Application by SSE Slough Multifuel Limited for Slough Multifuel Extension Project
The Examining Authority's written questions and requests for information (ExQ1)
Issued on 28 January 2023

Responses are due by Deadline 2 on 23 March 2023

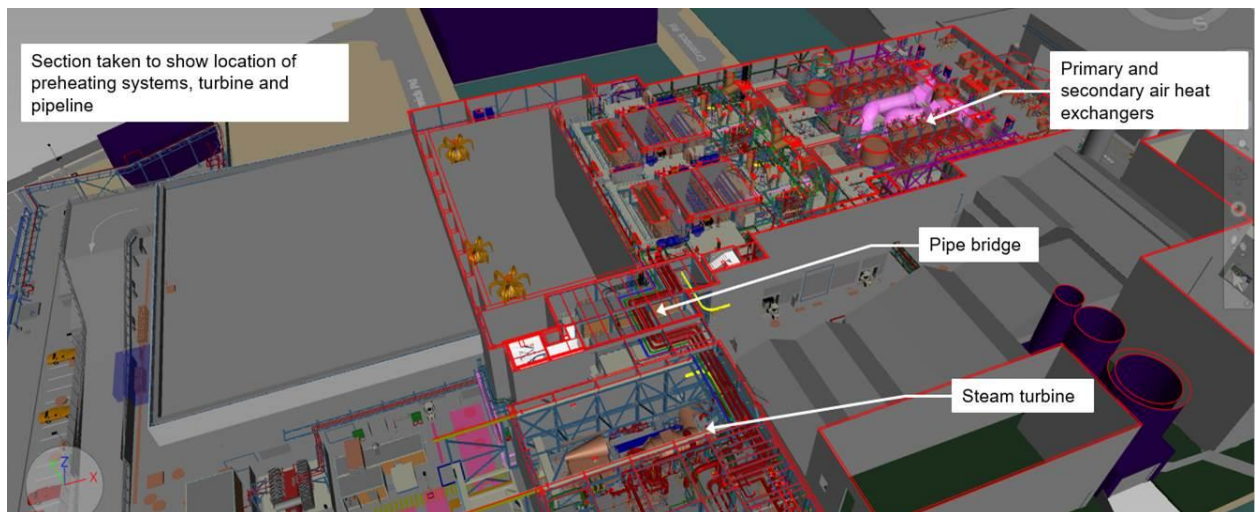
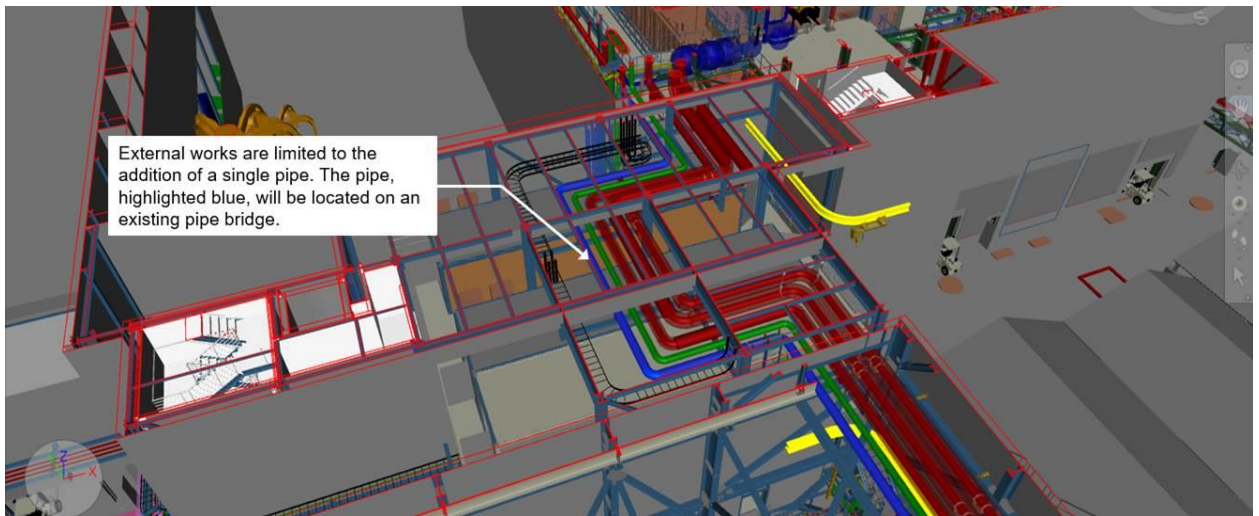
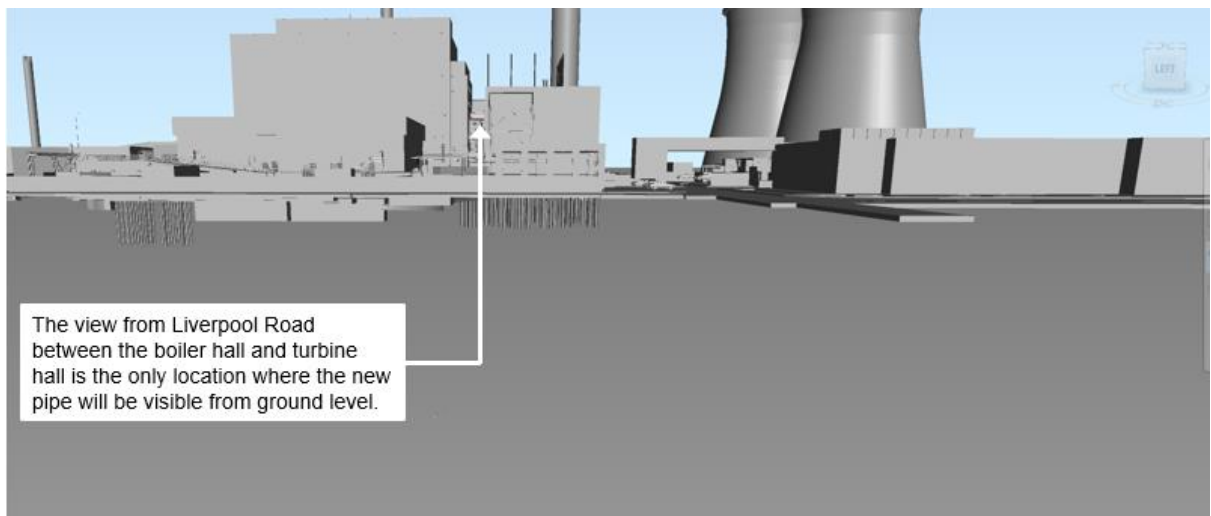
Q1.2.12	Applicant	Please review the DCO and EM and update the references to the Department for Energy Security and Net Zero (subject to confirmation).
3.	Air Quality and Emissions	
Q1.3.1	Applicant	Paragraphs 2.5.1 to 2.5.3 of ES Chapter 2: The Proposed Project [APP-027] and paragraph 8.1.5 of ES Chapter 8: Air Quality [APP-033], outline how the Proposed Development seeks to increase the generating capacity of the consented scheme. Please clarify the point at which (within the Energy from Waste process) the efficiencies and increased gross electricity generation capacity would be delivered by 'interventions' as part of the Proposed Development. For the ExA to better understand these points, the Applicant is requested to provide a process flow(s)/schematic block diagram(s) showing the Energy from Waste process which clearly identifies these interventions. In responding please have particular regard to the combustion element in demonstrating the assertions that "The Proposed Project does not introduce any new emissions nor change the exhaust gas parameters" (paragraph 8.8.16 of [APP-033]) and that the pre-heating of combustion air would be achieved without the use of additional fuel [APP-027, paragraph 2.5.1].
